**From:** [REDACTED]  
**To:** [Planning Comments \(Shared Mailbox\)](#)  
**Cc:** [REDACTED]  
**Subject:** Objection to Application Ref: 6/2023/2089/HOUSE - Freny Cottage 41 Northaw Road East Cuffley, EN6 4LU  
**Date:** 01 November 2023 09:37:01  
**Importance:** High

**Re: Second Application. Reference: 6/2023/2089/HOUSE  
Proposed Development at: Freny Cottage 41 Northaw Road East, Cuffley, Potters Bar EN6 4LU (the "Application")**

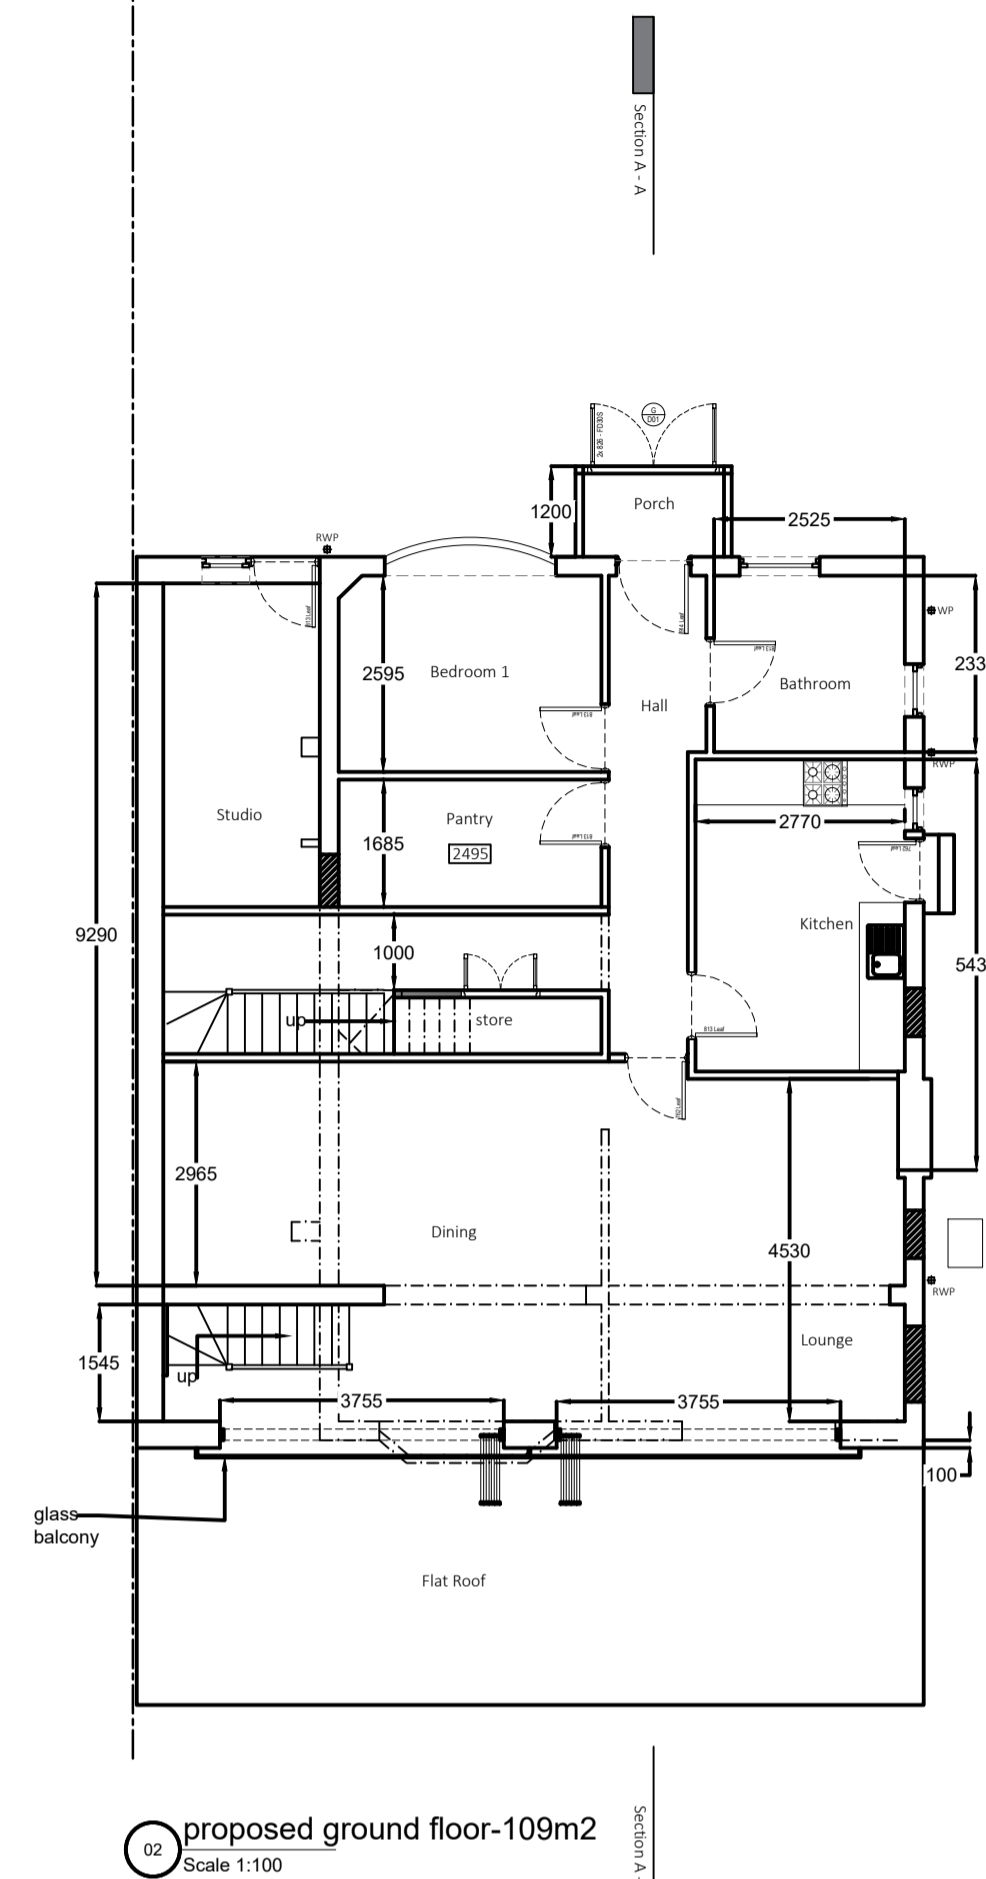
- A. The additional ridge height will render this building a sore thumb, and it will not

blend with neighbouring properties.

- B. **Privacy.** The additional height will allow dormer windows to look down into neighbouring properties.

Our right to light will be lost if the roof is allowed to be extended to near the boundary with No.43.

It appears that the 45 degree of the Cuffley Neighbourhood Plan D1( c ) (see No.6 below), has been contravened. This will result in loss of light to our principal bedroom, as well as other habitable rooms.

The dormers facing No.43 will be very close to the boundary line. Further, they have openable and unobscured windows. This contravenes D1 ( b ) of the Cuffley Neighbourhood Plan.

Further, the lack of detail in the drawing makes it difficult to understand from the Application how the adjoining properties will be protected from overlooking, loss of privacy and also the potential loss of light.

The Application contains side elevation glazing, which overlooks adjacent properties. This glazing is avoidable. No glazing should be allowed. The Application contravenes D1 ( b ).

We believe that the expansion of the roof over the side extension to the boundary with No.43 as well as the additional ridge height, both result in increased overshadowing and would significantly reduce the light to our main bedroom in contravention of D1 ( c ).

The 5.2metre ground floor extension, will be built on the boundary line with No.43 and require multiple mature hedges and to be removed to accommodate.

One of the many grey areas of the Application is the creation of a roof terrace. The single storey extension lines up with openable windows, in front of which there is currently a balcony. The flat roof area must not be able to be used as a balcony, as this would result in a significant loss of privacy and overshadowing.

The Application seems to request a new party wall astride the property boundary. We do not agree to this. Nor do we agree to any foundations being built astride the boundary or on our property at No.43. The current Party Walls are in good order.
